## **Development Facilitation Team (DFT) – Review Comments**

**Project No: PR-2024-010135   Date: 02/26/2025   Agenda Item: #3 Zone Atlas Page: K-13**

**Request: Eliminate an existing lot line to allow for the proposed addition to existing residence.**

### **Application For: MINOR PLT-2025-00003 – MINOR PLAT**

**Lot Line Elimination
PLAT OF
LOT 4-A, BLOCK 2
T.G. APODACA ADDITION**
WITHIN SECTION 19, T.10N., R.3E., N.M.P.M.,
TOWN OF ALBUQUERQUE GRANT
CITY OF ALBUQUERQUE, BERNALILLO COUNTY, NEW MEXICO
BEING A REPLAT OF
LOTS 4 & 5, BLOCK 2, T.G. APODACA ADDITION
JUNE 2024

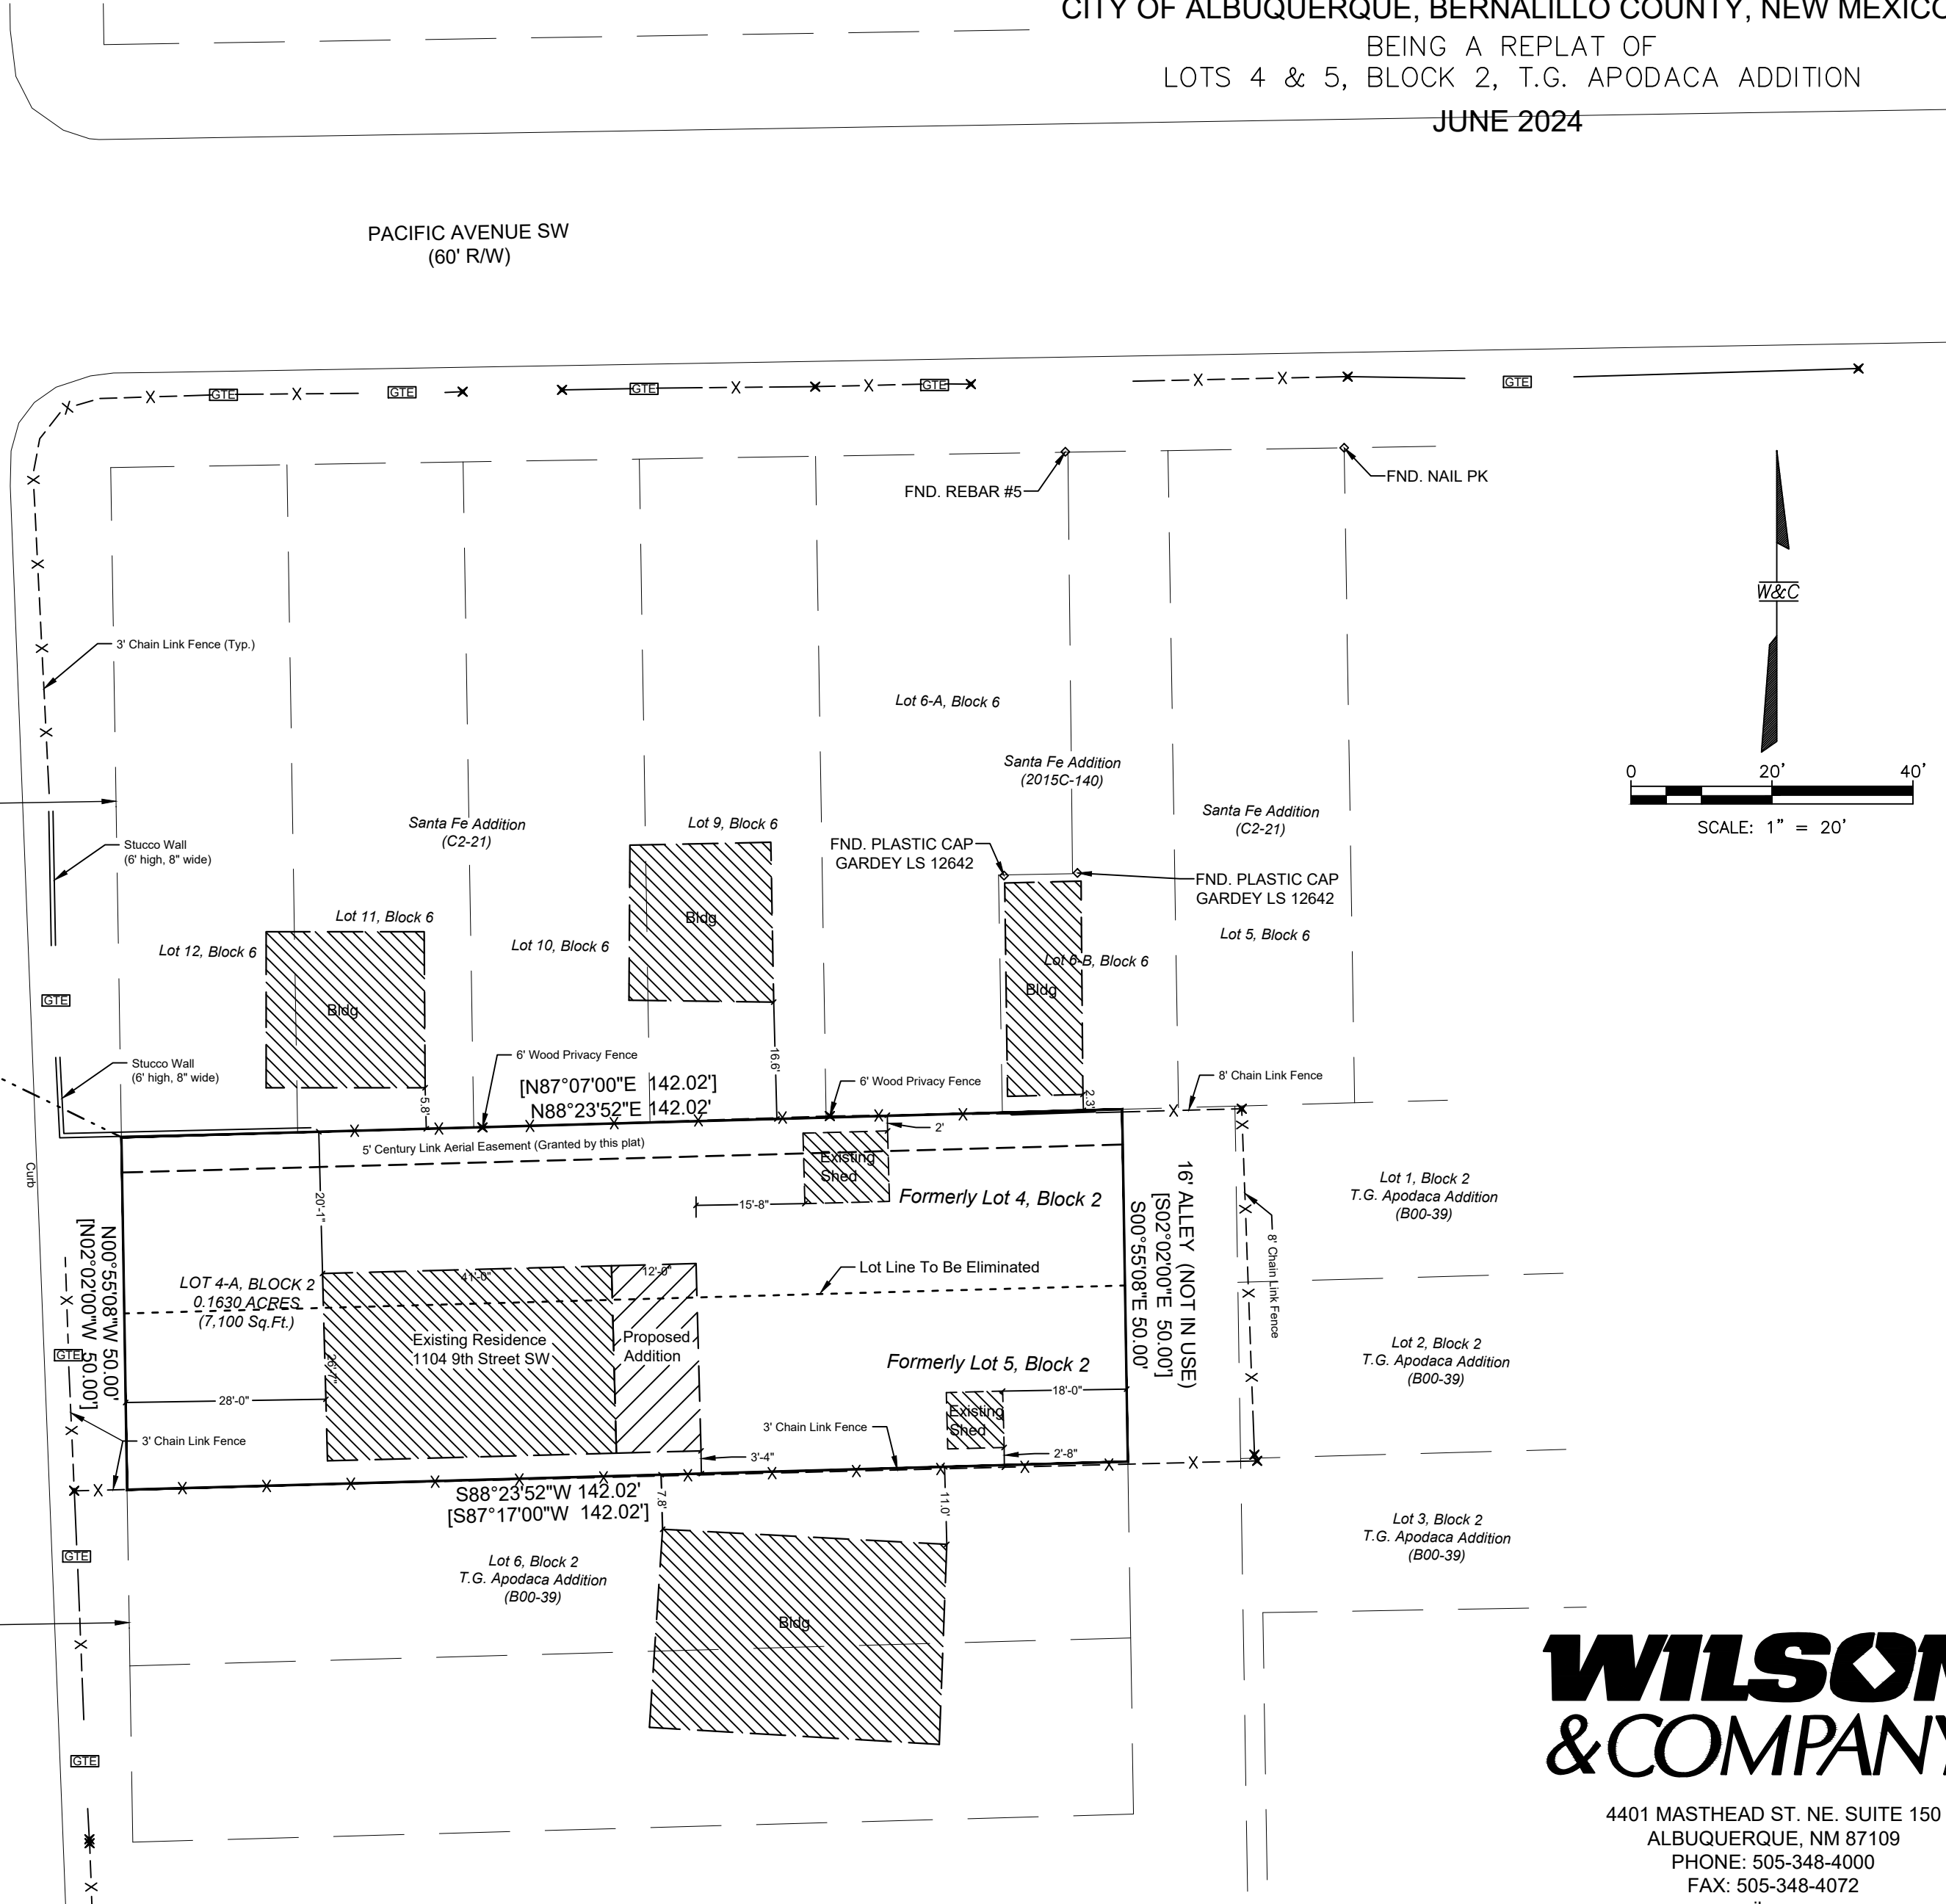
- At the hearing, please explain and confirm the details of the proposed Preliminary/Final plat for the DHO.
  - Clarify the differences in the submitted plat sheet and site sketch. Structures and property lines do not appear to match.

- The Project & Application numbers must be added to the Plat before final sign-off.
  - A copy of the AGIS-approved DXF file must also be submitted before the final sign-off of the plat.

RESIDENTIAL ADDITION
	@ 1104 9TH STREET SW
PROPOSED ADDITION SITE PLAN	
SCALE: 1" = 20'-0"	SHEET 1 OF 1

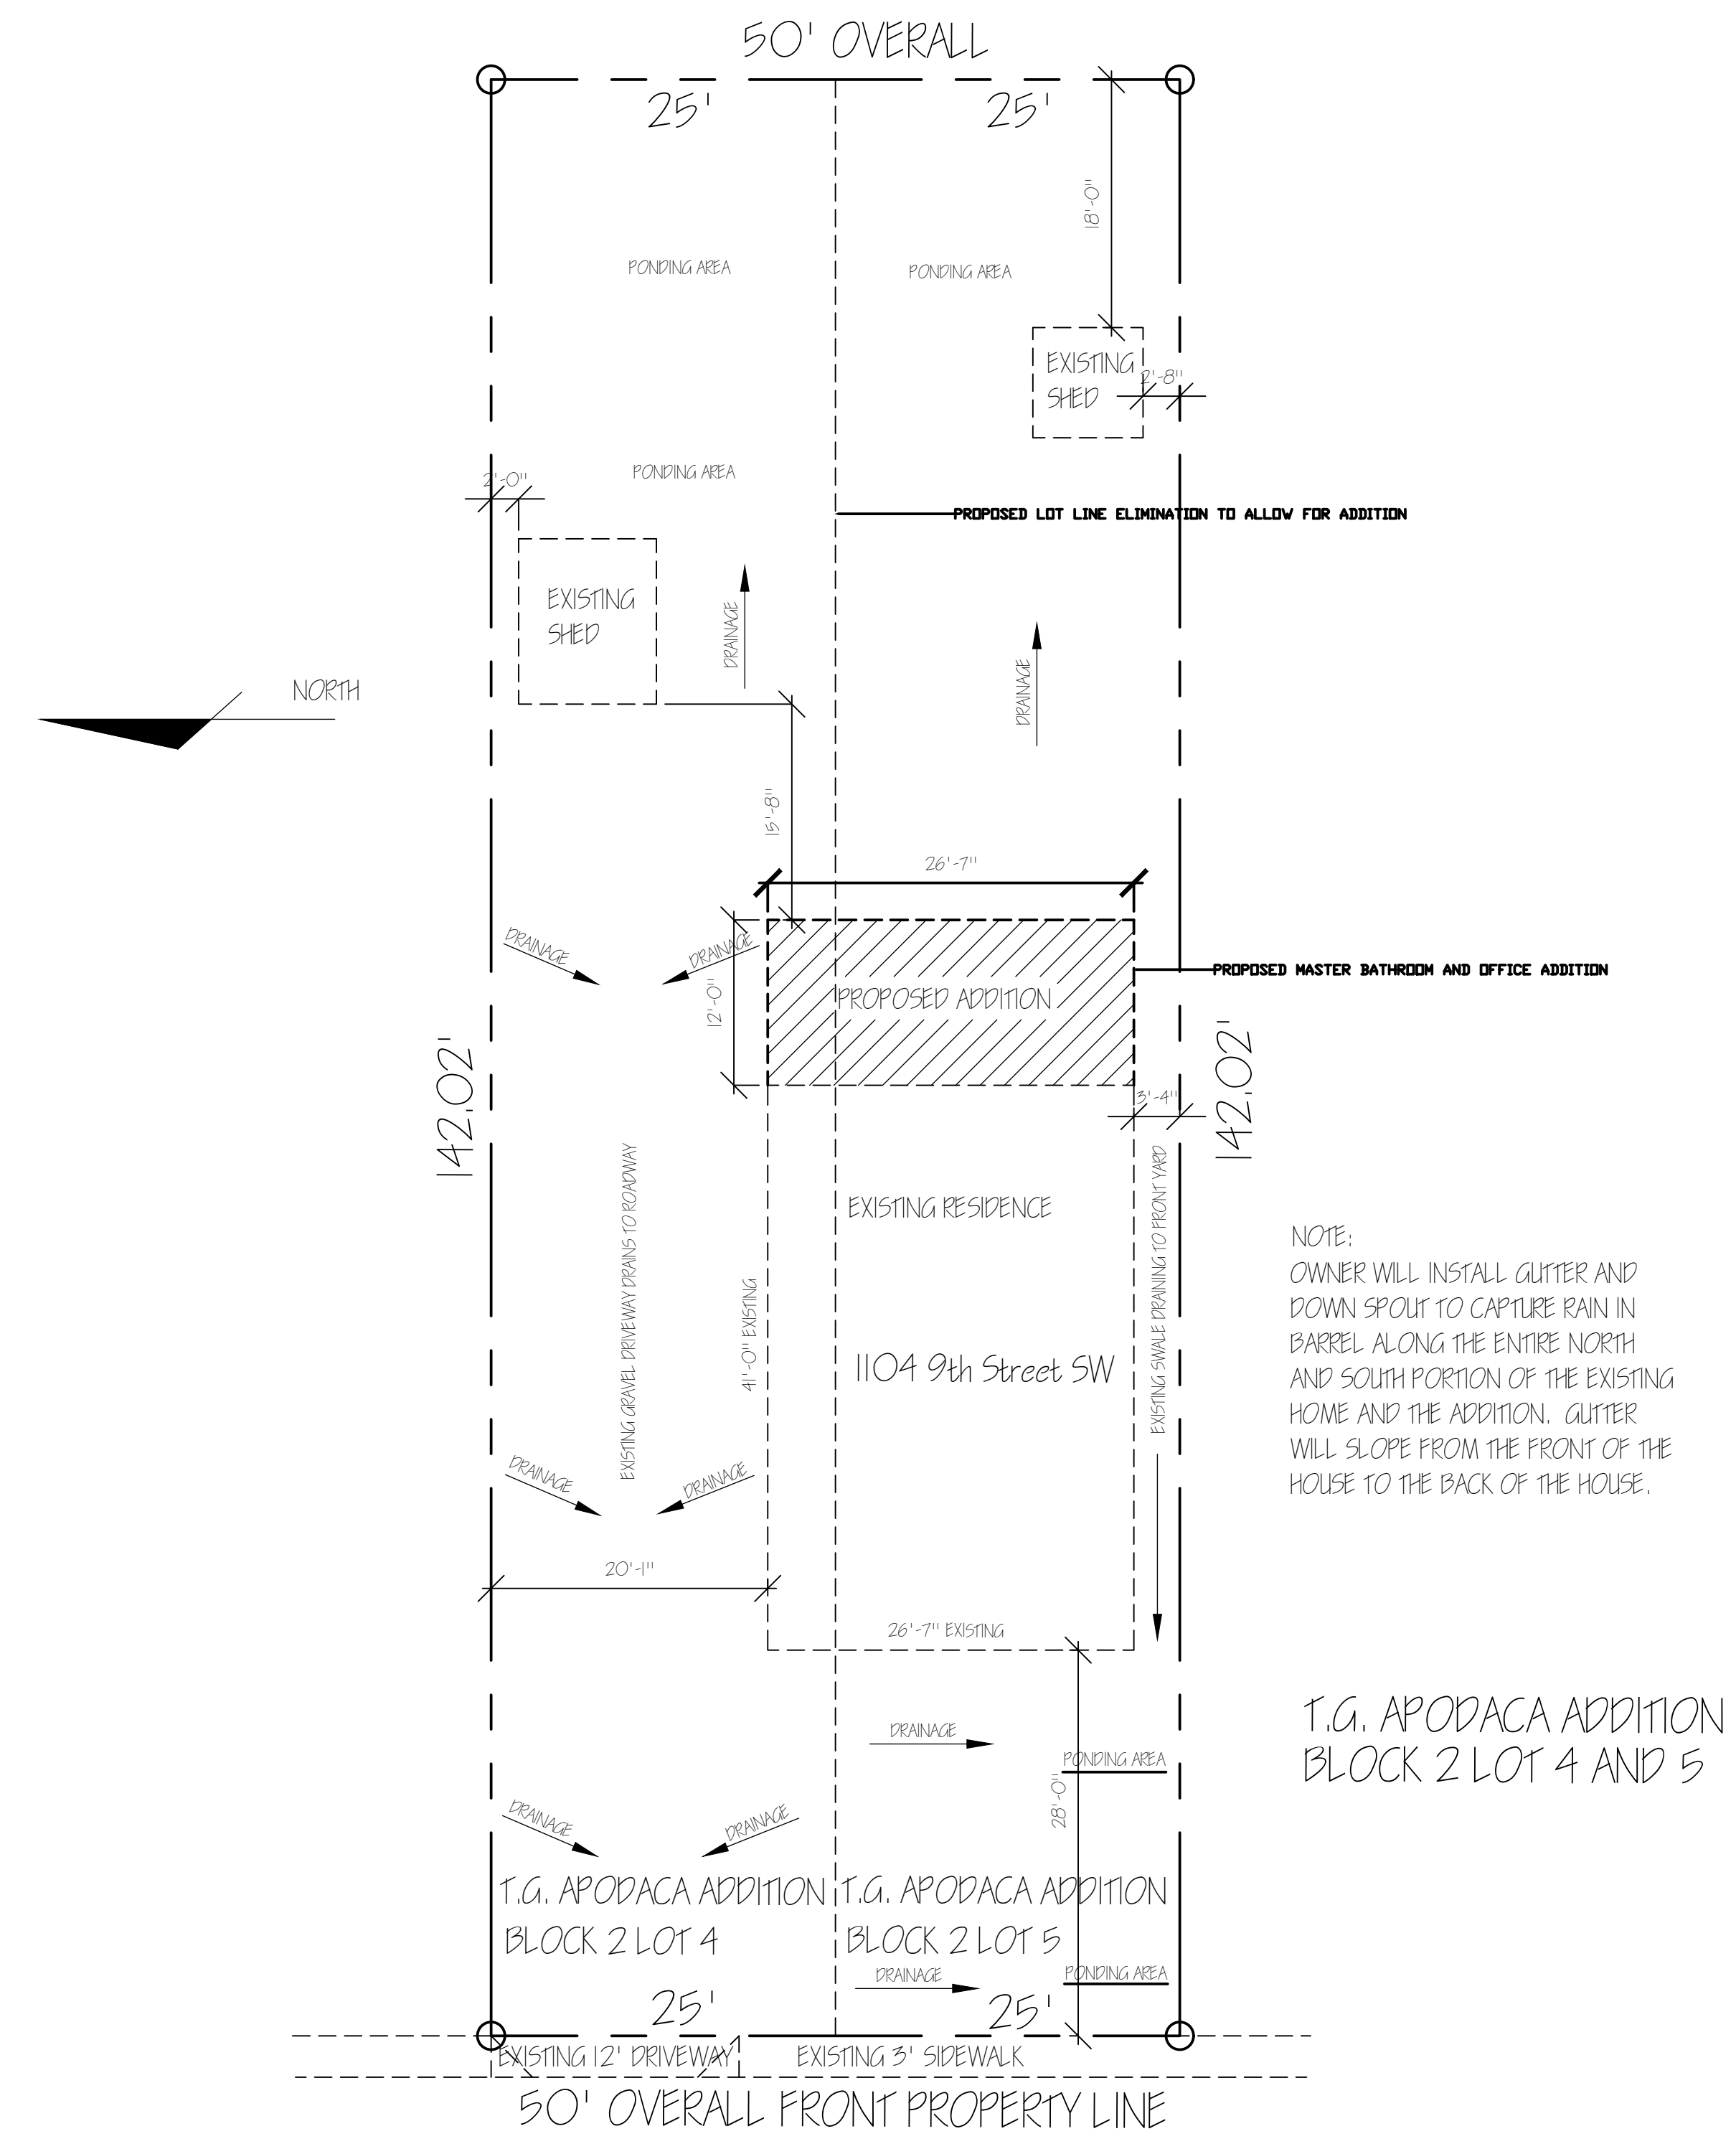
- A plat approval would not be affected. *However, for the proposed addition shown on the sketch, you'll need to confirm with Code Enforcement if setback standards from IDO section 3-4-B-3--(CPO-1) and/or section 5-1 are being met. \*Include Hydrology in that analysis.*  
*Side, minimum: 3 feet for lots less than 40 feet in width outside the Main Street area, or the setback required for adequate spacing between buildings as required by with Articles 14-1, 14-2, and 14-3 of ROA 1994 (Uniform Administrative Code and Technical Codes, Fire Code, and Uniform Housing Code).*

- Clarify sidewalk development. Please include ADA access details, sidewalk width construction details, and if an Infrastructure List will be a part of the platting action.  
*Per Transportation: 9th is a local road and requires 5' sidewalk with a 4' to 6' landscape buffer.*
